Highways England Planning Response (HEPR 16-01)

Formal Recommendation to an Application for Planning Permission

Council's Reference: WA/63/21/PL

Proposal: Proposed alternative vehicular accesses off Tye Lane and emergency access off Avisford Park Road, along with minor highway works following WA/95/18/RES (resubmission following WA/93/20/PL). This site is CIL Zone 2 (Zero Rated) as other development.

VIEWPORT 1 - PROPOSED RESIDENTIAL ACCESS AT TYE LANE

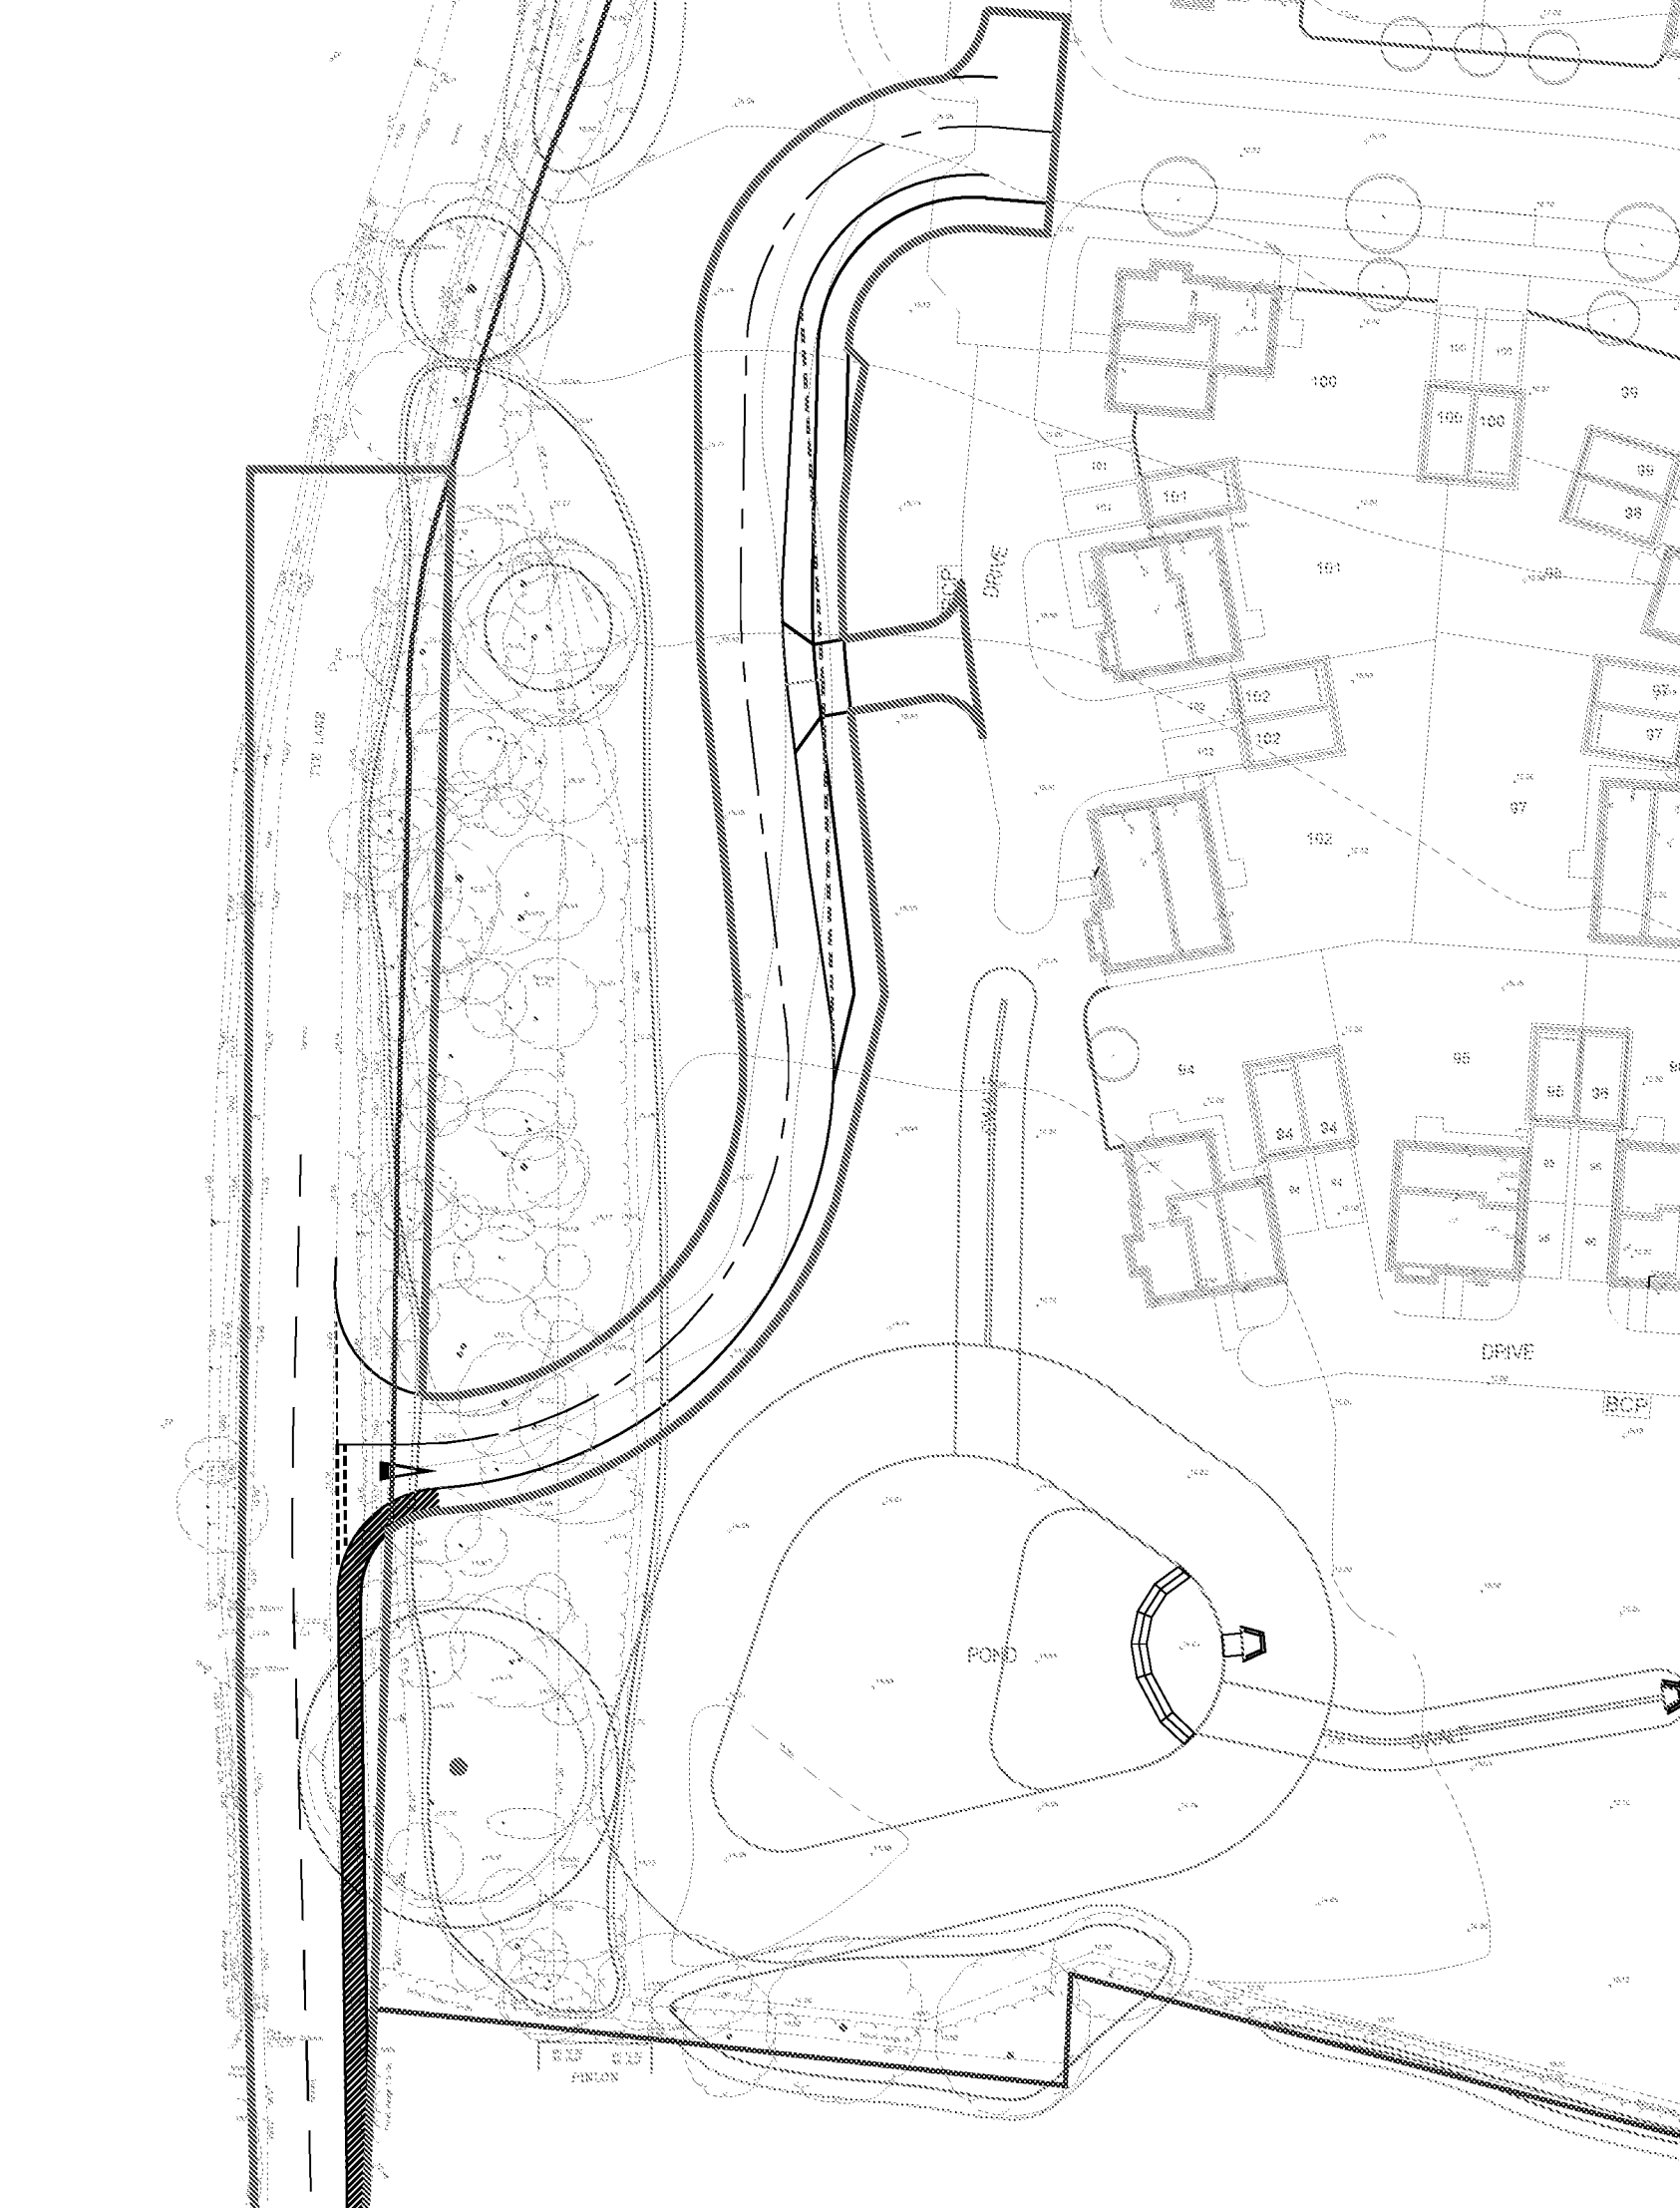
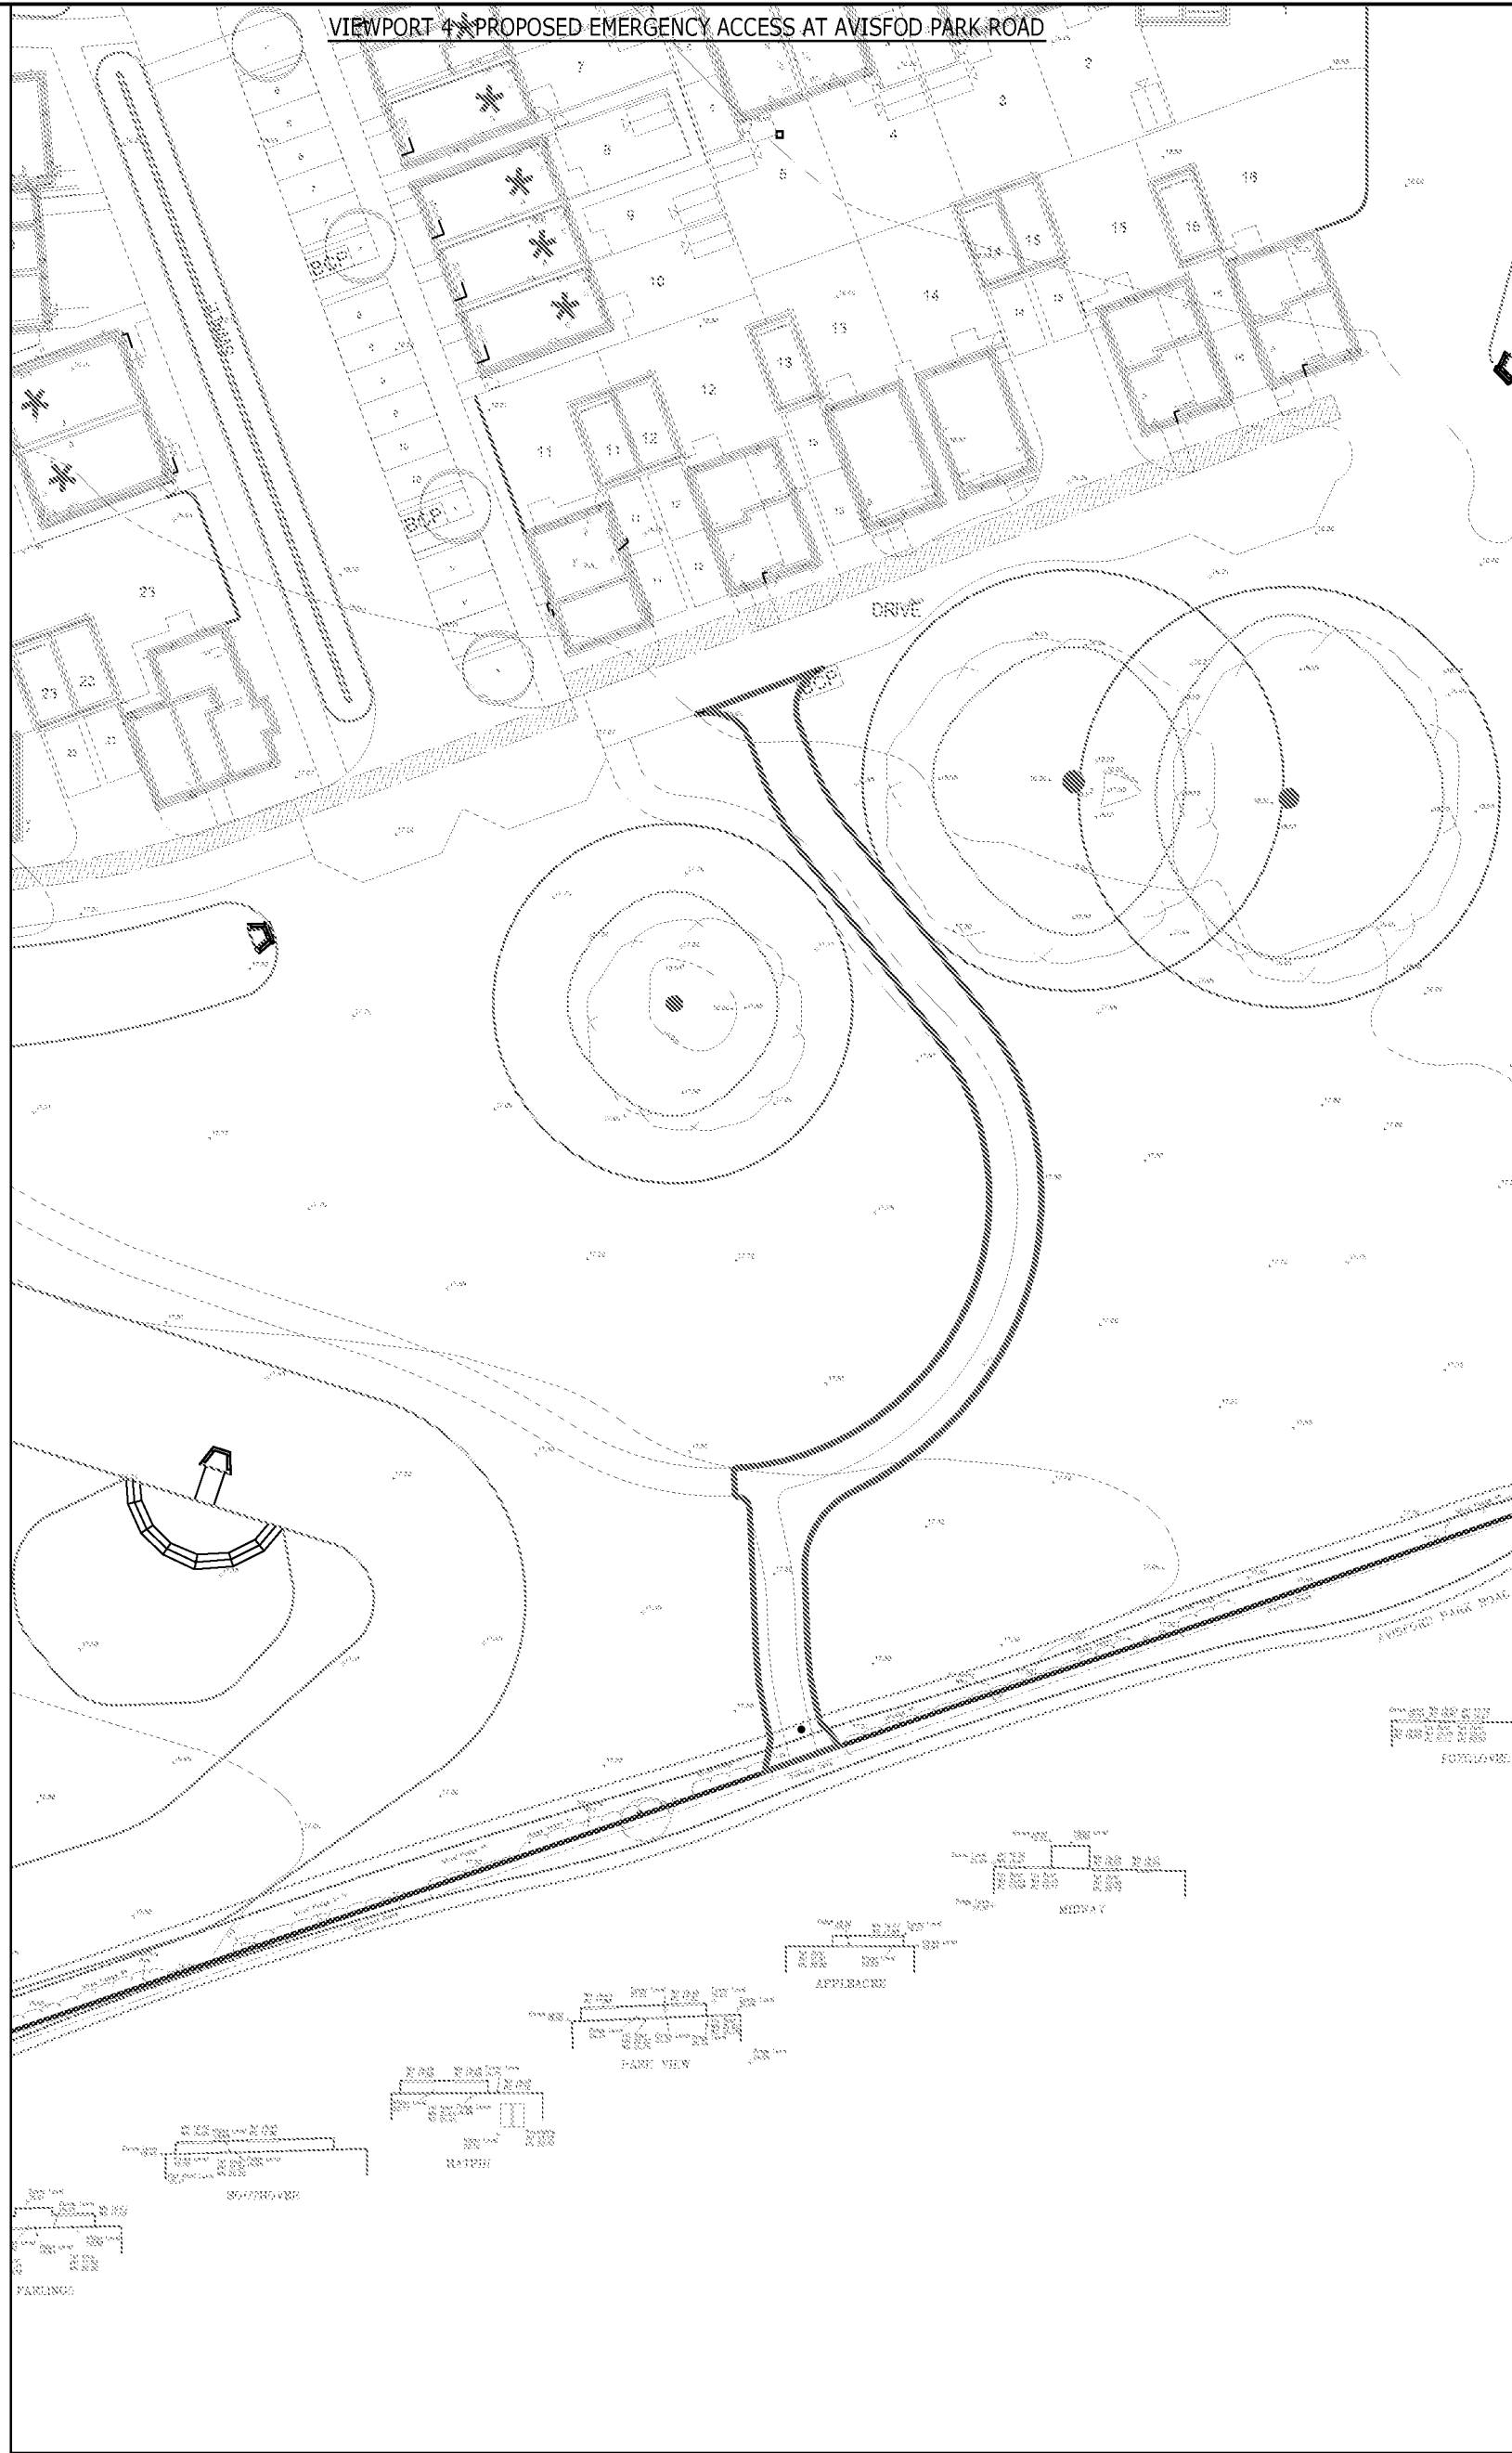
1. Prior to bringing the development hereby permitted into use, the scheme of highways works forming the A27/Tye Lane junction improvements as shown on the Ardent Consulting Engineers drawing No. 183248-005 Rev D 'PROPOSED A27 / TYE LANE JUNCTION' dated June 2021 (or other such alternative scheme that may be agreed in writing by the local planning authority who shall consult Highways England) shall be completed and opened for use.

- In the event that the Arundel Bypass proceeds (option 5Bv1) and Tye Lane is disconnected from the A27 then the agreed works as shown on the Ardent Consulting Engineers drawing No. 183248-005 Rev D 'PROPOSED A27 / TYE LANE JUNCTION' dated June 2021 will be deemed unnecessary.
- In the event that the Arundel Bypass proceeds (option 5Bv1) and Tye Lane is disconnected from the A27 then the agreed contribution of £400k for the scheme of works at the A27/A29 Fontwell Avenue Roundabout shall be an alternative scheme of works that Highways England considers necessary
